COFFS HARBOUR CITY COUNCIL

Your ref: MP05_0129 MOD 1
Our ref: 5248442 (DA 0698/09)

RE: Exhibition of Section 75W Modification, Lakes Estate Residential Subdivision, North Boambee Road, North Boambee Valley (MP05_0129)

ROADS AND MOVEMENT ACCESS PLAN

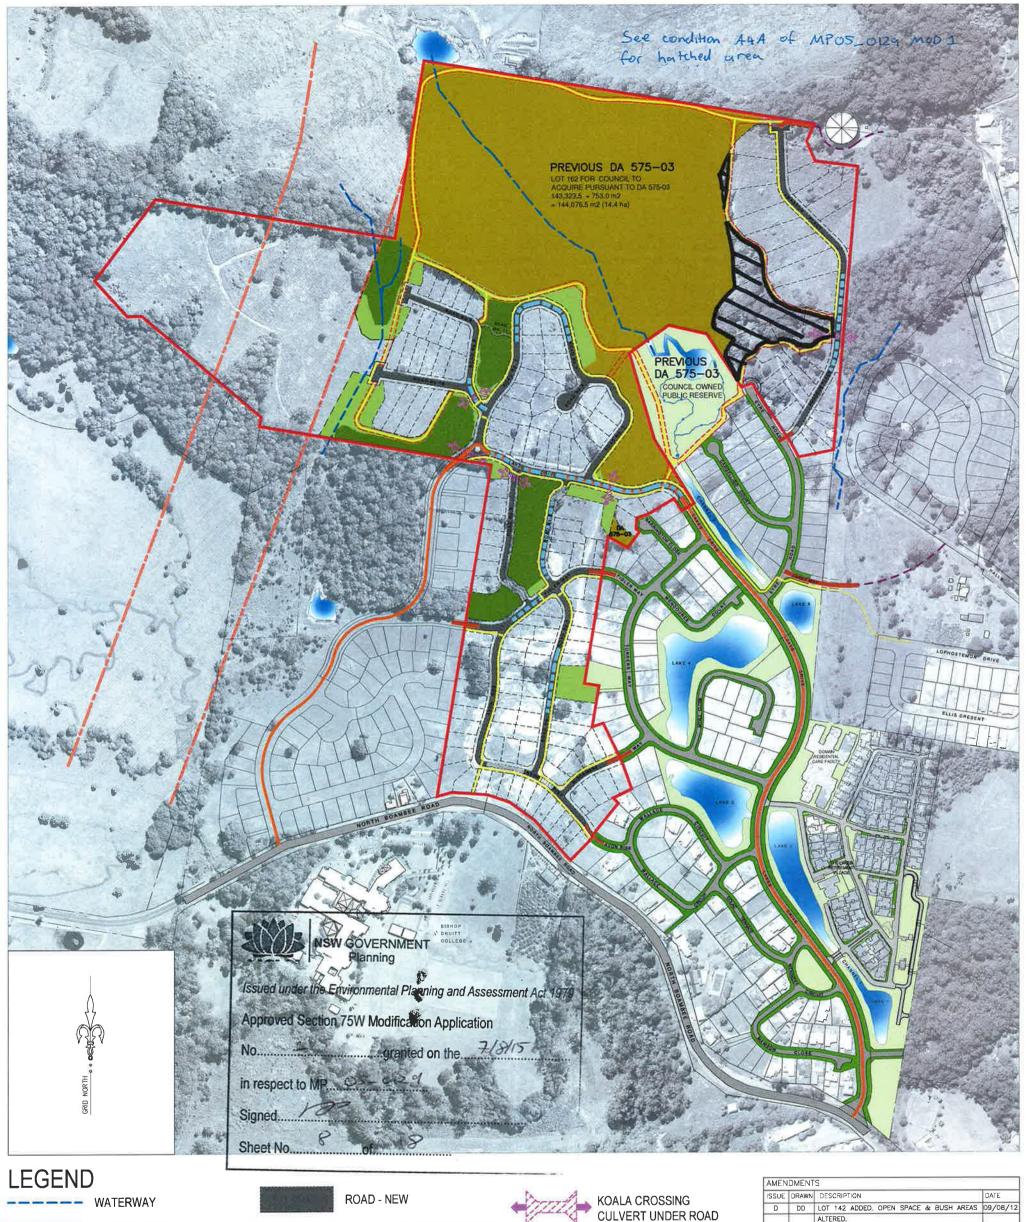
- Council does not support the proposal to modify part e) of Condition 'B1 – Subdivision Design Modification', which requires the provision of a road link from Amadeus Place to the adjoining residentially zoned lands to the northeast of the site.

The justification provided by the applicant is noted, however, the connection to the adjoining land is considered important in providing an alternative egress from Amadeus Place. For example, in the event of a bushfire that cuts off the southern portion of the road.

Fire trails:

Fire trails are proposed to be located within the middle of individual blocks, which is likely to result in addition clearing requirements and duplication of management areas for public and private. The functionality of a fire trail transecting multiple lots is problematic, particularly under emergency conditions, due to high likelihood of multiple gating/fencing by various individual landowners and questions around the long term management of the trail as it will no longer be under Council management. Both fire trail relocations are not supported. In addition Council will need to duplicate a management trail at the Reserve/allotment interface
